HyNet North West

Annex D

CORRESPONDENCES Rev B

**21/02454/AAC Request for a formal opinion on the scope of an
Environmental Statement (ES) under Regulation 10 and 11 of the
Environmental Impact Assessment Regulations 2017: HyNet North West
Carbon Dioxide Pipeline**

**Pentre Halkyn - Block Valve Station (BVS) Drainage Layout**

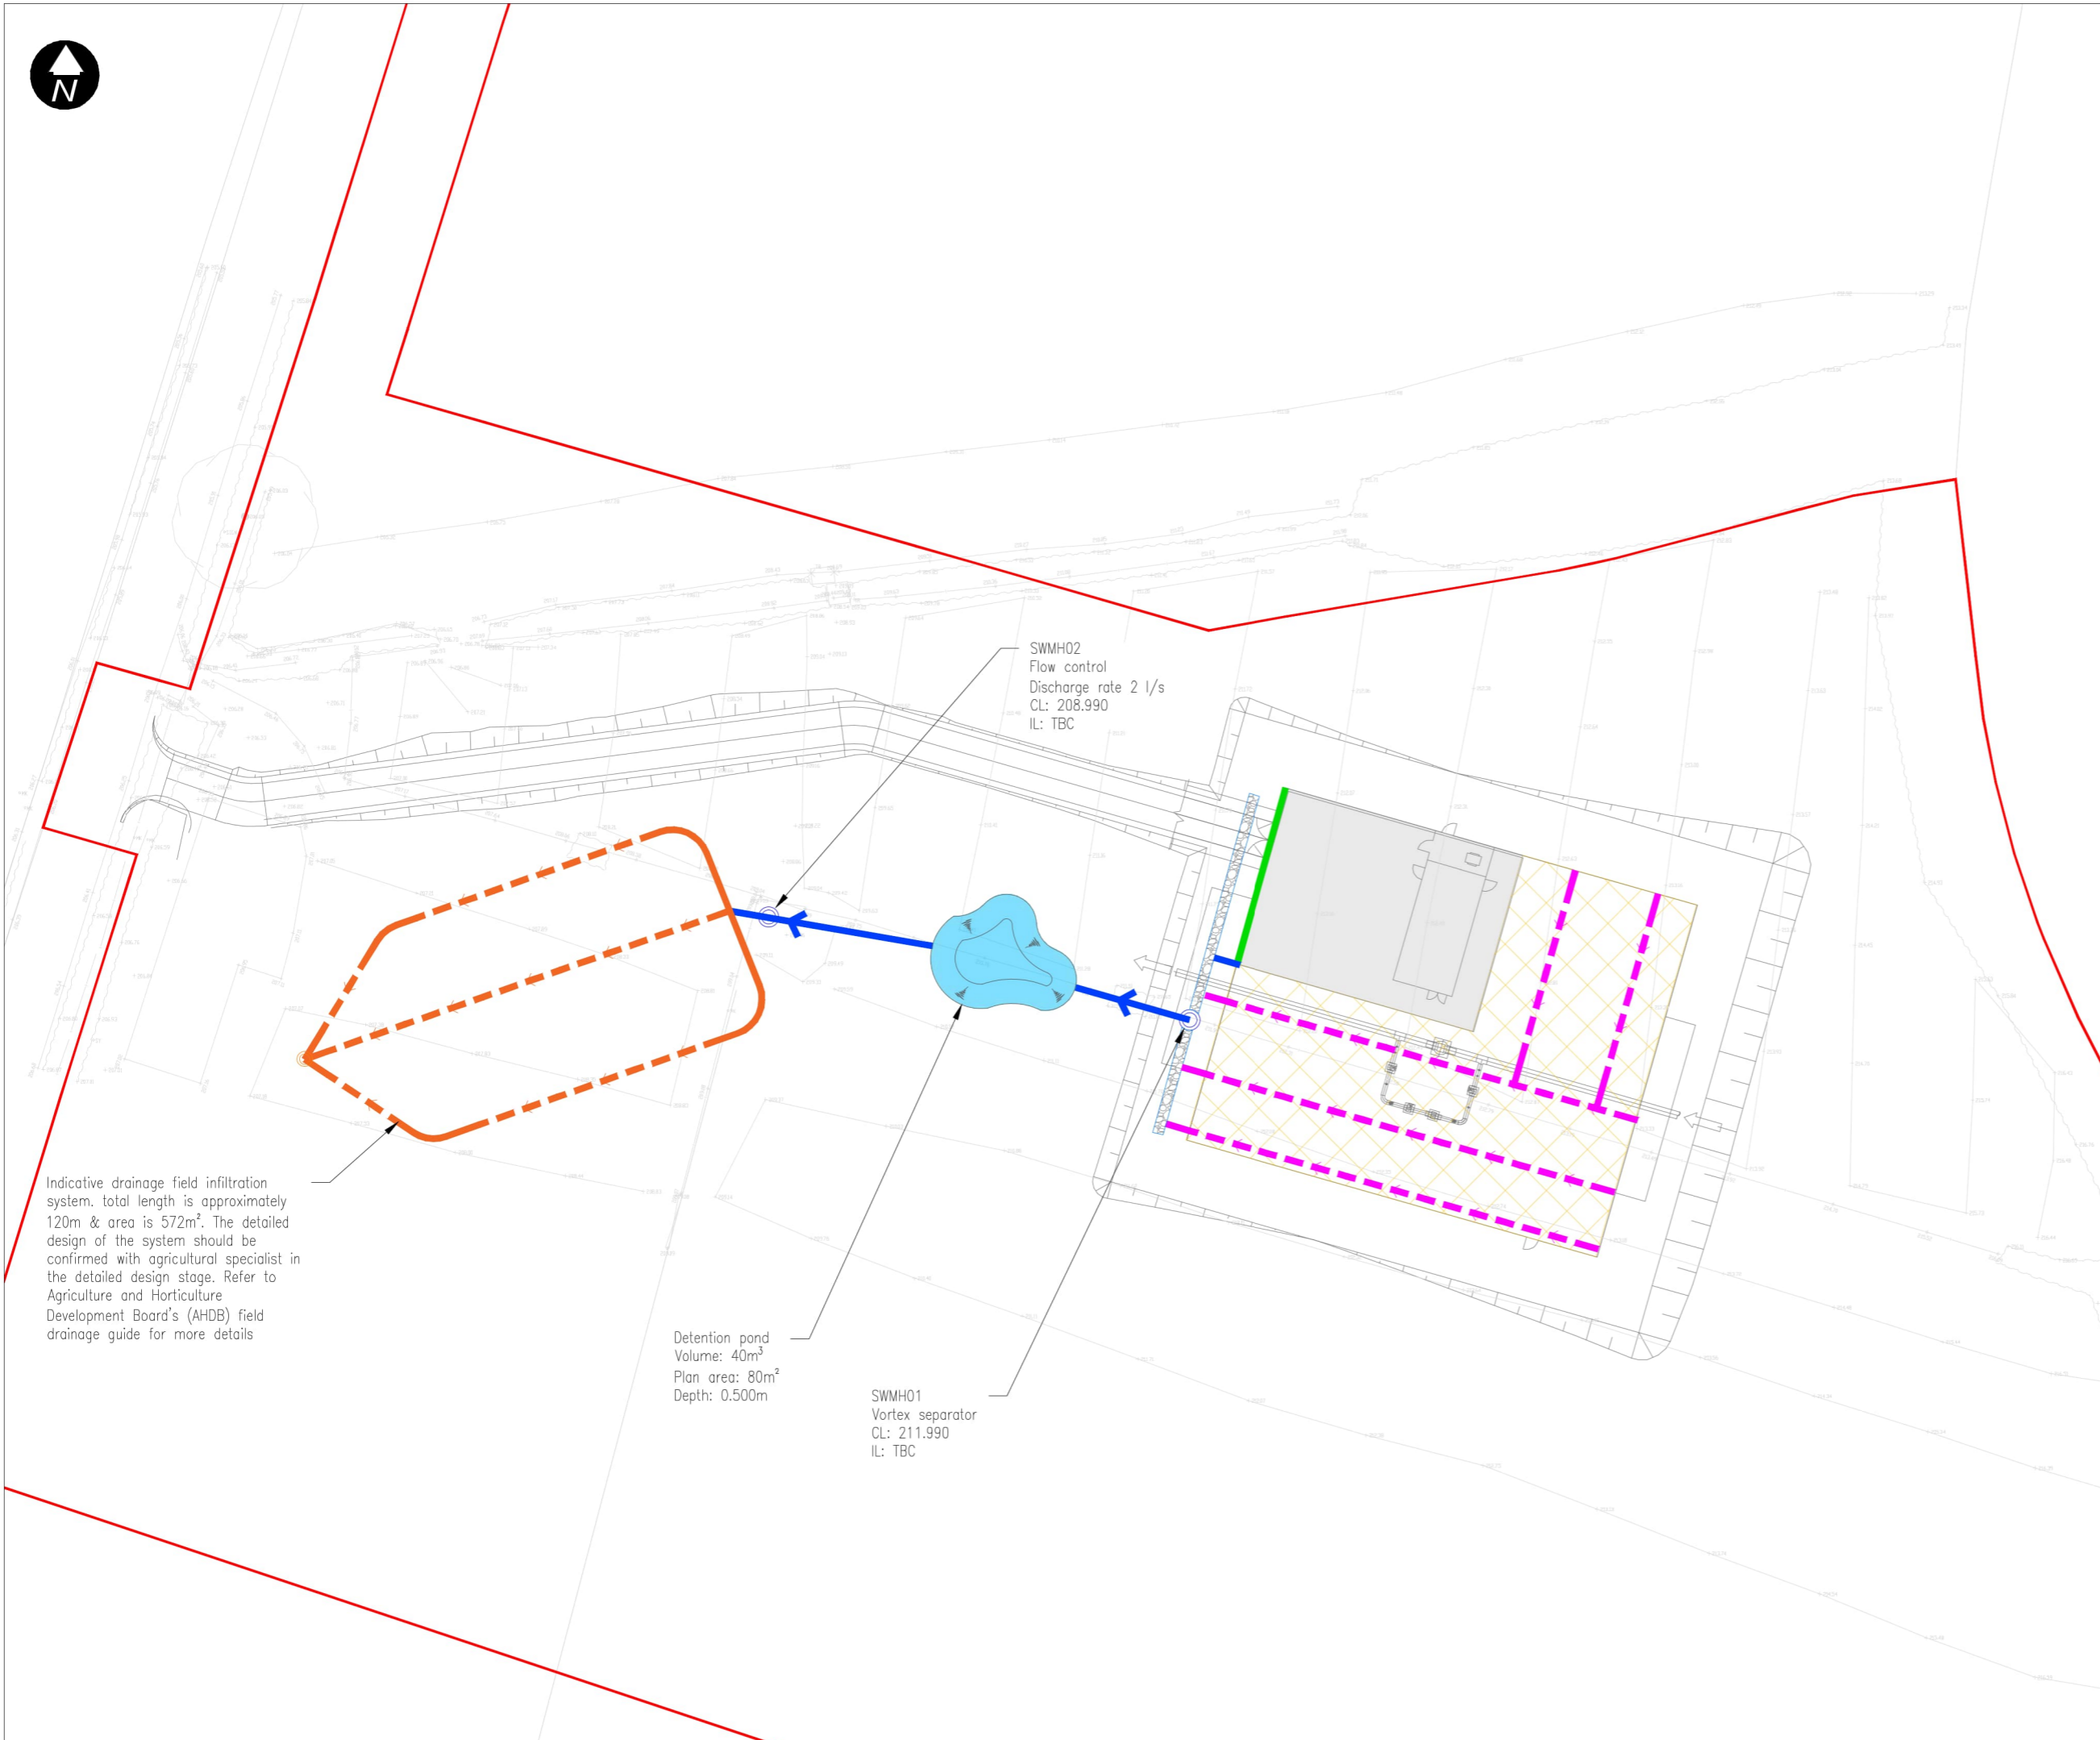
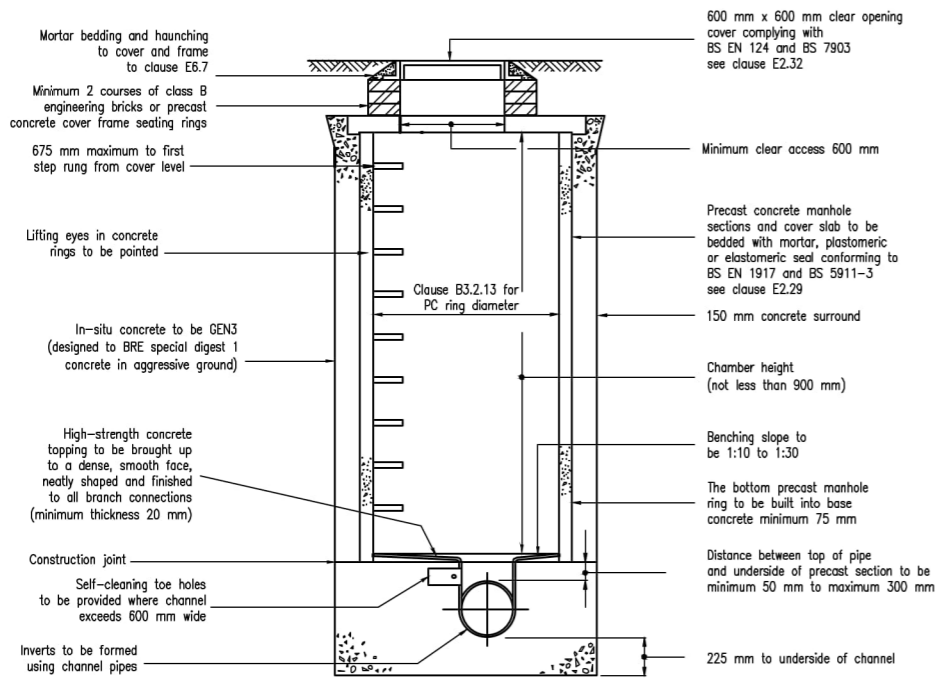
- 3) *Pentre-Halkyn and Babell – use of slow infiltration system using a drainage field system spread over a larger area*

Drainage Field System

As all options are exhausted under the Drainage Hierarchy we decided to revisit Priority Level 2 and produce a slow infiltration system using a drainage field system spread over a larger area. Does the consultant agree with this approach?

It appears that all drainage options have been exhausted and as such we would be happy for an infiltration based system to be used. The use of permeable surfaces is encouraged as to create a large storage and infiltrating surface area.
